Our Reference: SYD17/01529/03 (A25872763)
Department's Ref: SSD 8859

**NOTICE OF EXHIBITION OF EIS FOR ELIZABETH DRIVE SUB-DIVISION, CECIL PARK
1111-1141 ELIZABETH DRIVE, CECIL PARK**

Roads and Maritime has reviewed the submitted information and does not grant concurrence under Section 138 of the *Roads Act 1993* for the proposed road works on Elizabeth Drive and provides the following comments for Department's consideration:

drg no.		date		issue	
DA04		07/09/2018		DA

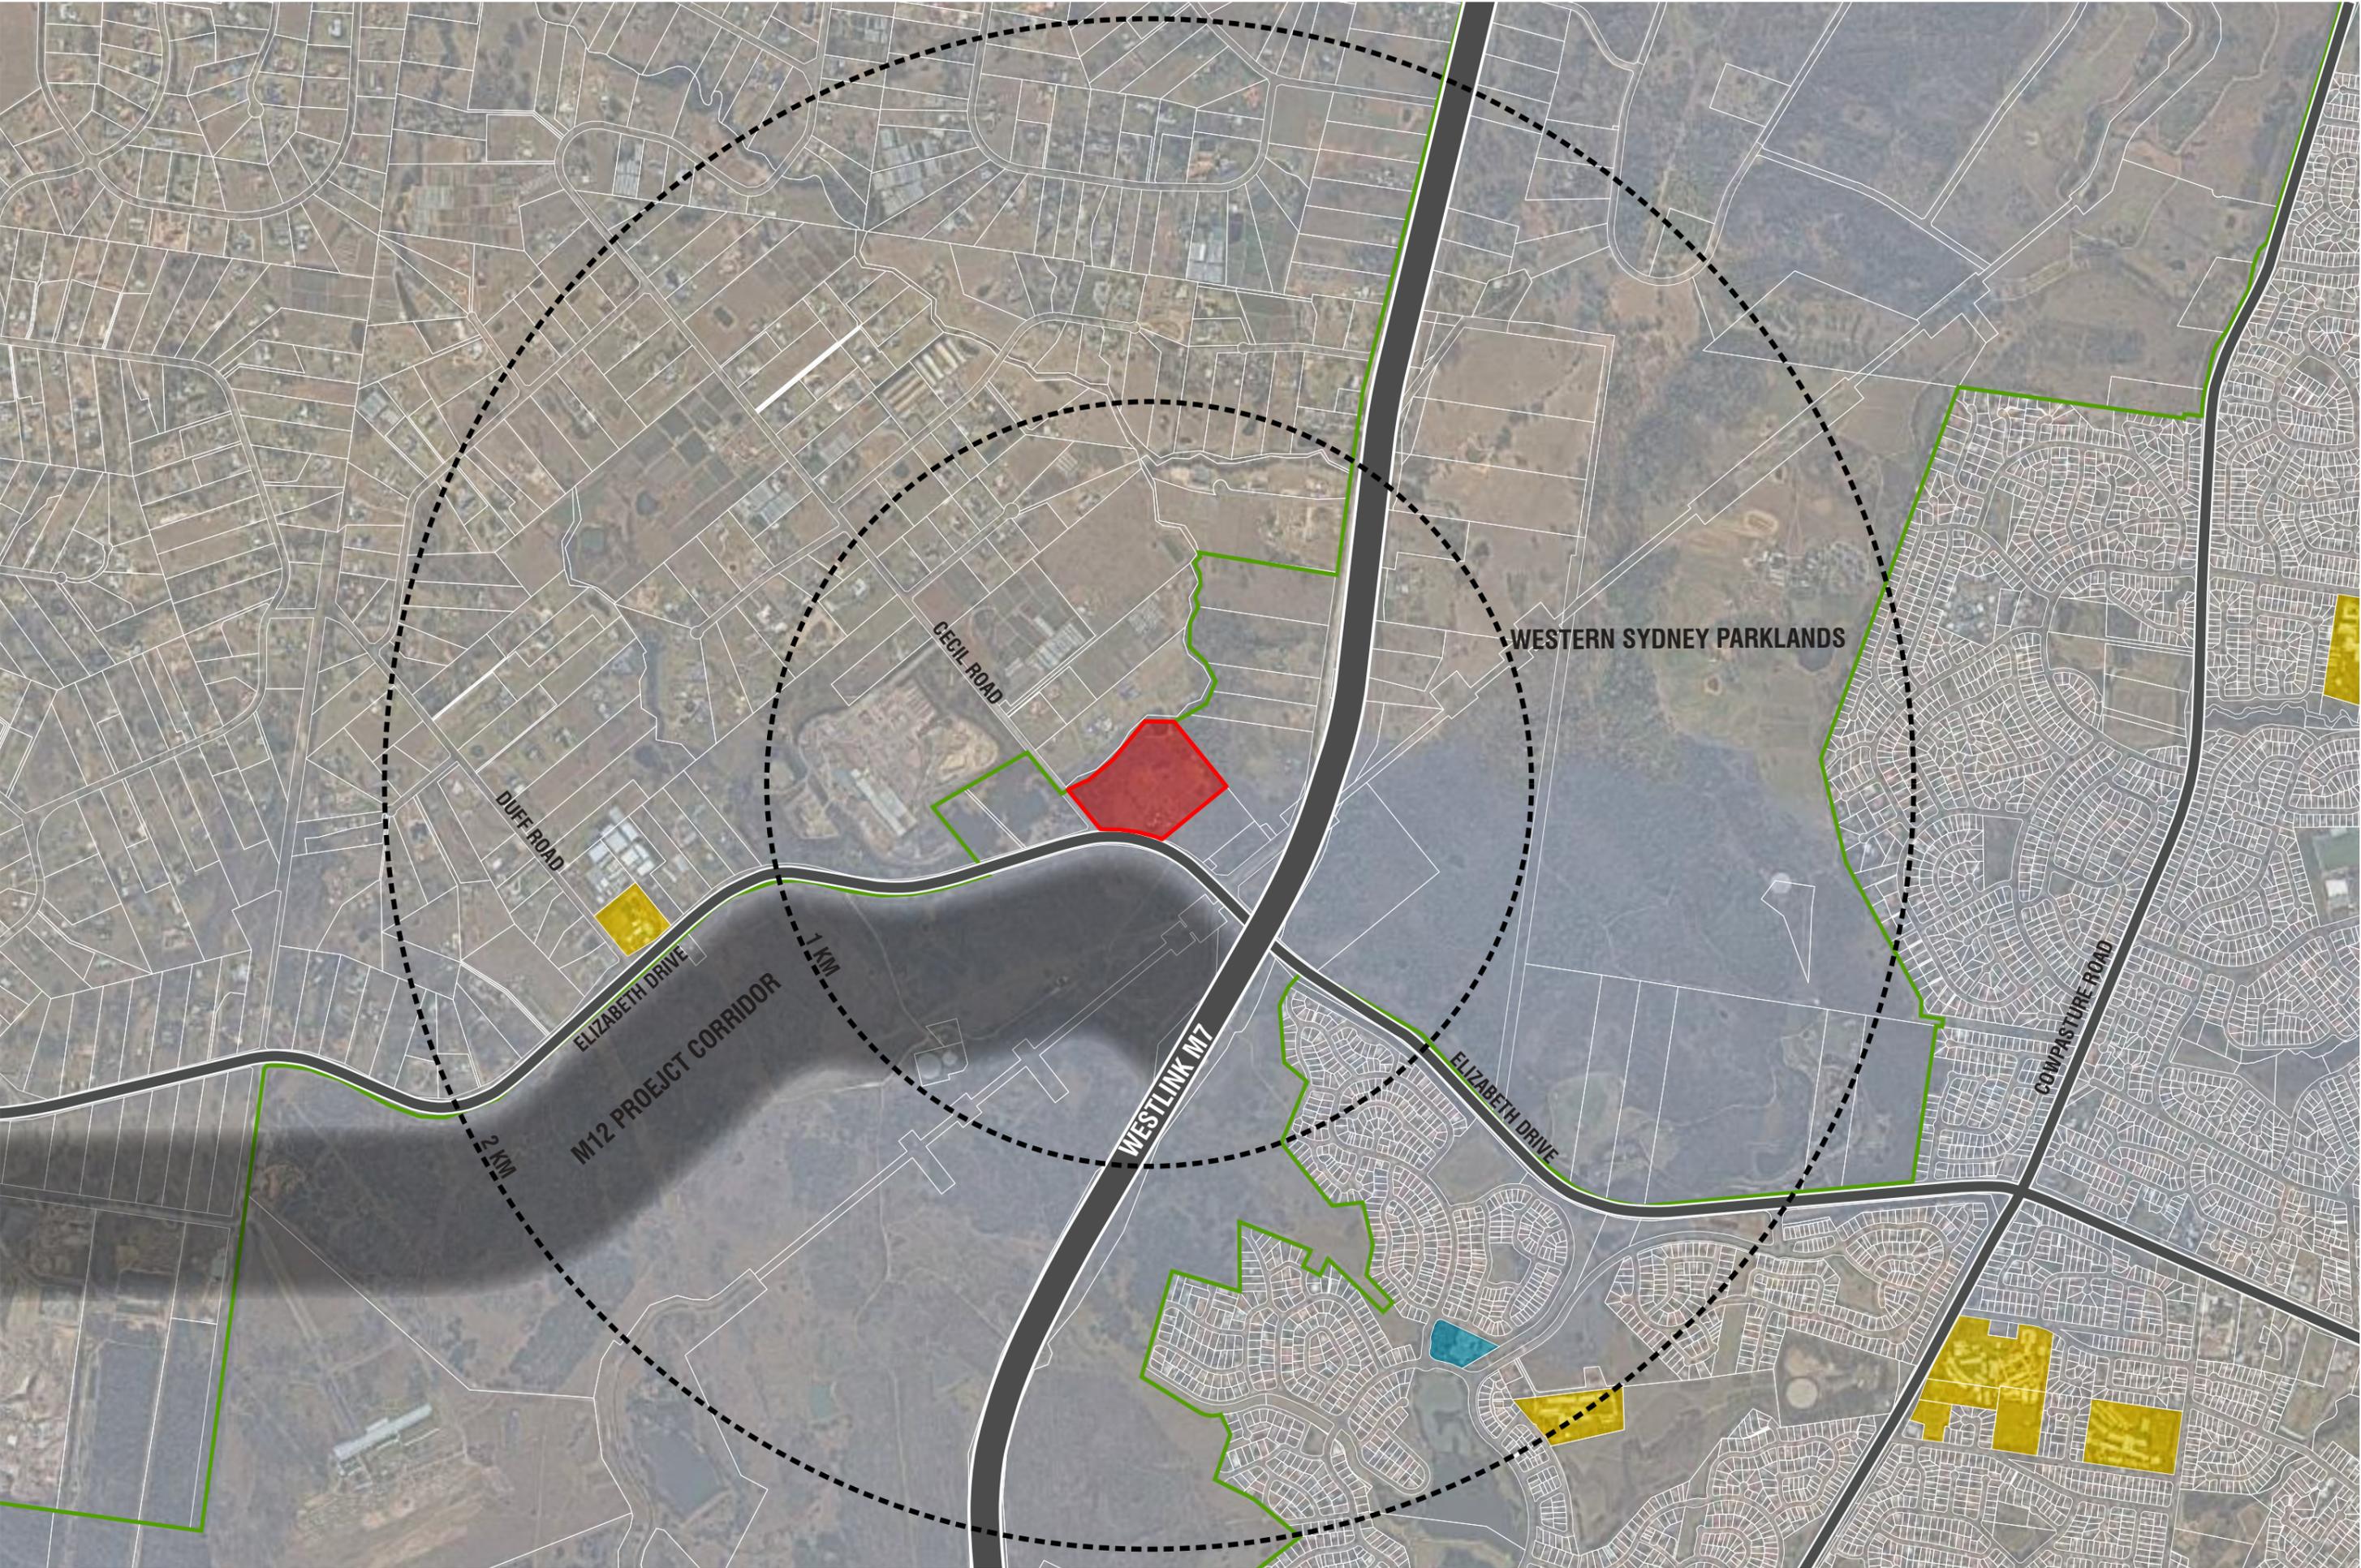
1. The subject development proposed construction of a service road to access three lots. Roads and Maritime does not support proposed service road based on road safety and network efficiency. It is advised to construct a deceleration lane instead of a service road to provide access to any future service station only.
2. The proposal included access to the fast food outlets via Elizabeth Drive. Roads and Maritime does not support any direct access to the fast food outlets from Elizabeth Drive since an alternate access is available through Local Road network (via Cecil Road). Therefore, except the service station all other access (including fast food outlets) should be provided via Local Road network. In this regard Roads and Maritime suggests physical separation to be provided within the site to comply with this requirement.

3. To access the service station from Elizabeth Drive a deceleration shall be provided. The proposed deceleration lane along Elizabeth Drive shall be designed to meet Roads and Maritime requirements, and endorsed by a suitably qualified practitioner. The design requirements shall be in accordance with AUSTROADS and other Australian Codes of Practice.

4. Access to the service station should be restricted with left in and left out access only via a deceleration lane. In this regard, it is requested to investigate and propose mechanism to restrict any right turn movements from the deceleration lane onto Elizabeth Drive

5. The deceleration may be constructed within the existing road reserve however land should be dedicated within the property boundary for any future relocation/construction of the deceleration lane. The land identified for deceleration lane should be identified as a separate lot in the subdivision plan and dedicated to Council as road.

6. Roads and Maritime does not support proposed roundabout in Elizabeth Drive at Cecil Road intersection. It should be noted that Roads and Maritime currently preparing a strategic road design for Elizabeth Drive within the vicinity where Cecil Road may be restricted with left in left out (LILO) movements only. However, as an interim measure it is advice to investigate the impact due to the subject development and propose mitigation measures at the subject intersection.
